Our Ref: WA/38/18/HH

**Town & Country Planning Act 1990 (as amended)
Town & country Planning (Development Management Procedure) (England) Order 2015
Application for Planning Permission for Works or Extension to a Dwelling**

Development New vehicular access with parking & turning.

Location Longacres Eastergate Lane Walberton

SITE LOCATION PLAN
AREA 4 HA
SCALE 1:1250 on A4
CENTRE COORDINATES: 495799, 106201

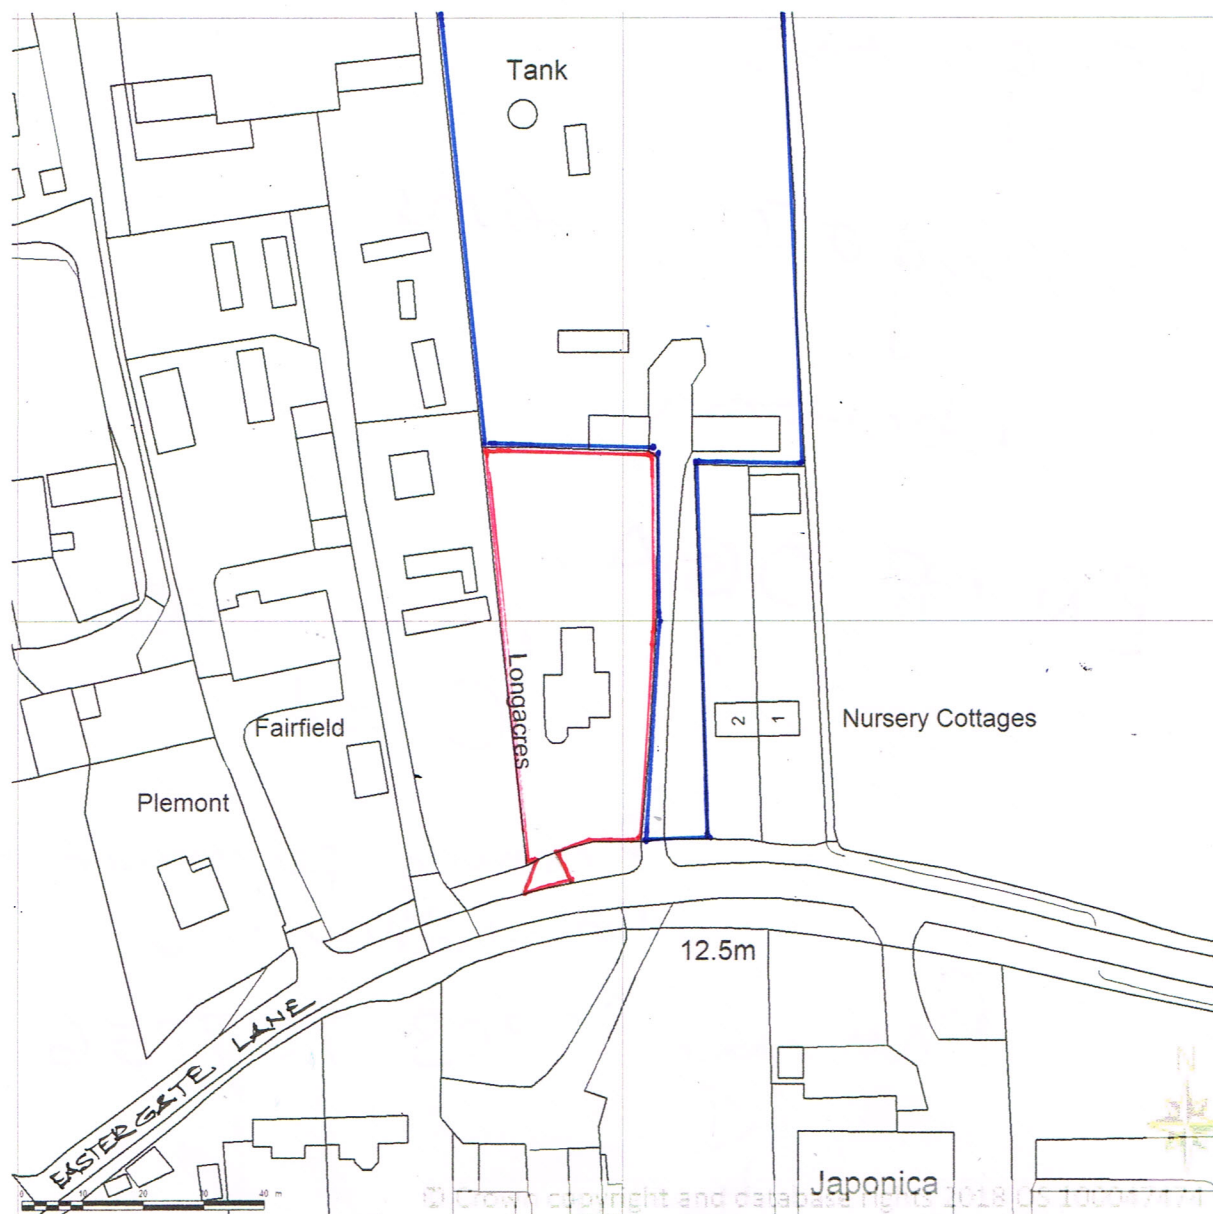
Location Plan Amend

Please submit 1 electronic or 3 paper copies of a location plan at a scale of 1:1250 or 1:2500 for rural areas. Further details of what must be included on the plan can be found in the National Validation Requirements. Please show the proposed access within the red edge. and provide one named road.
